Application no: H19/0424/98

Location: Pt OS 8525, Broadgate Road
Sutton St Edmunds
Spalding
Lincs

Amendment: As built - plans for farm buildings
Dwg.Nos. SM.02B; WD1890/1A & /1B

TOWN AND COUNTRY PLANNING ACT 1990
NOTICE OF ACCEPTANCE OF AMENDMENT

END ELEVATION

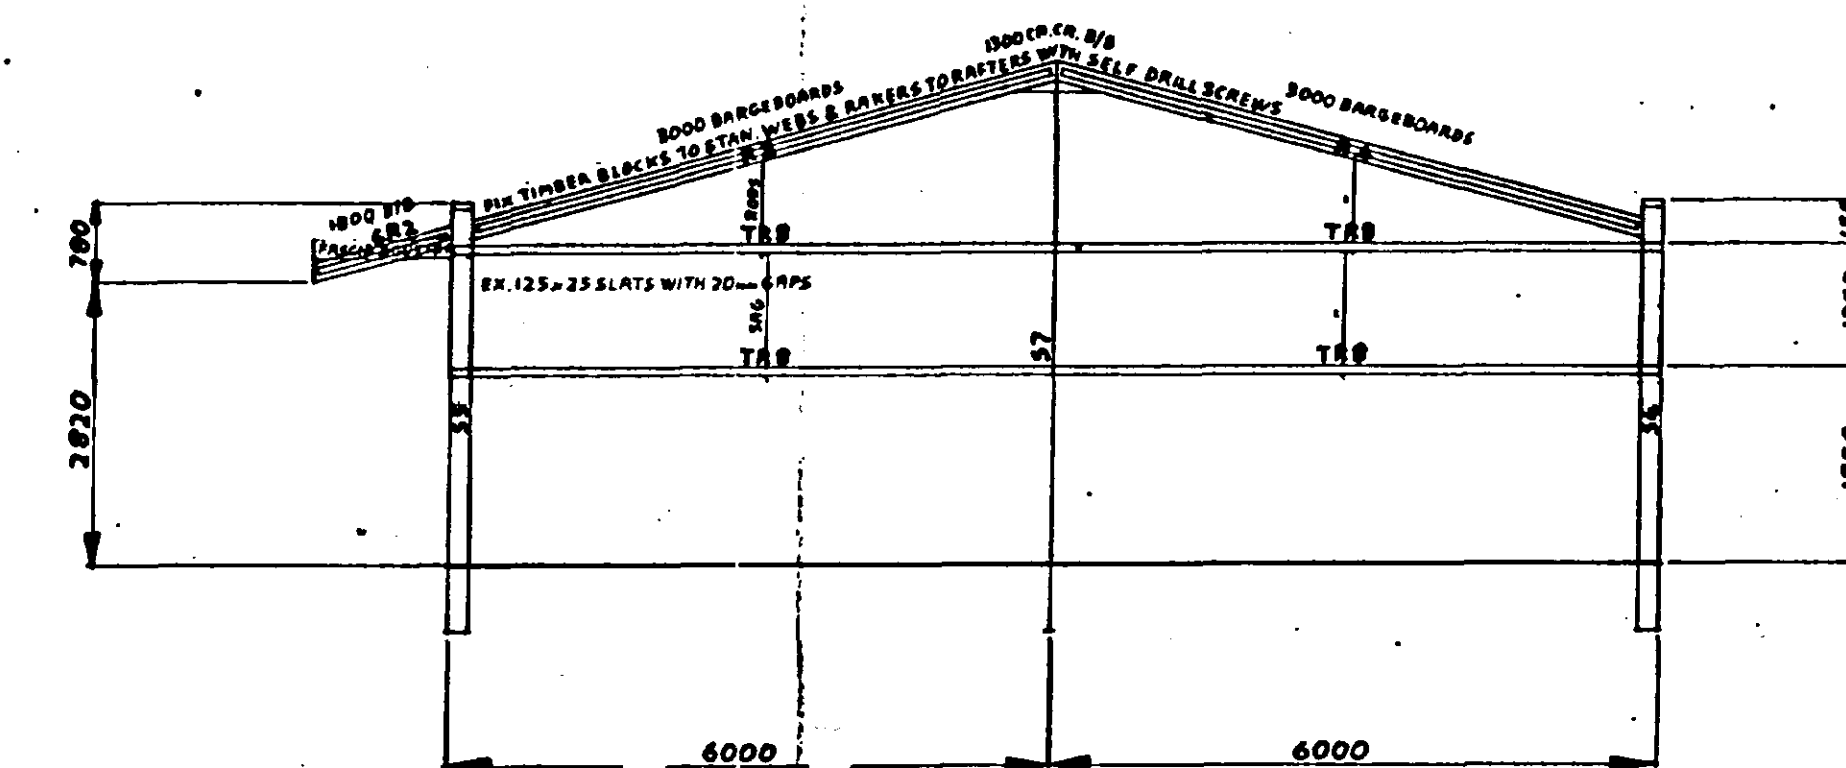
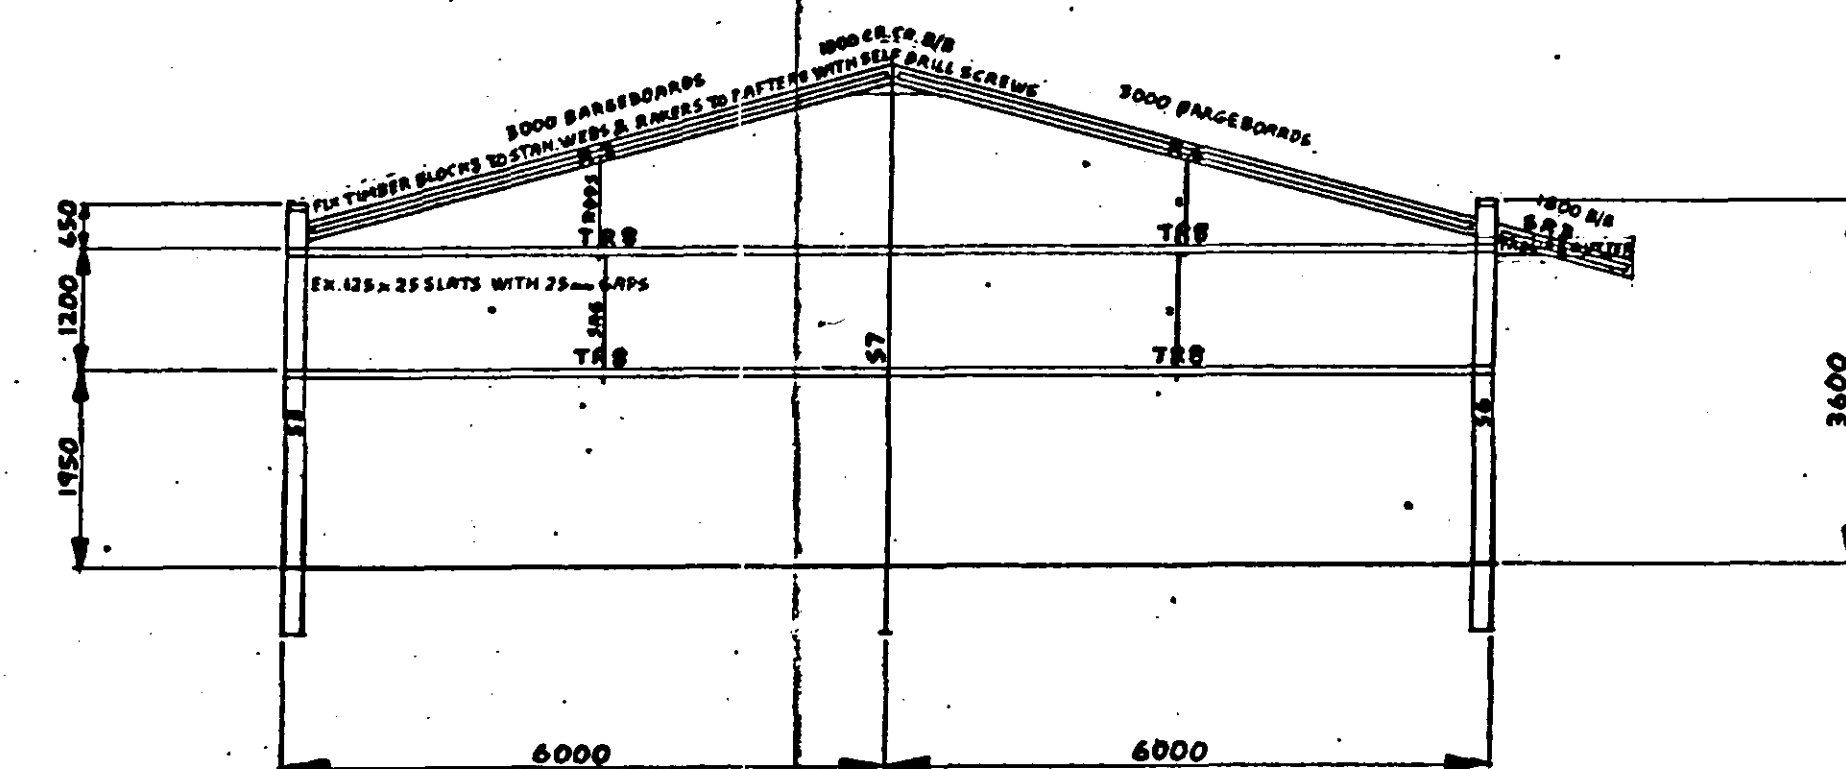
15. BUILT PLANS OF FARM
BUILDINGS.
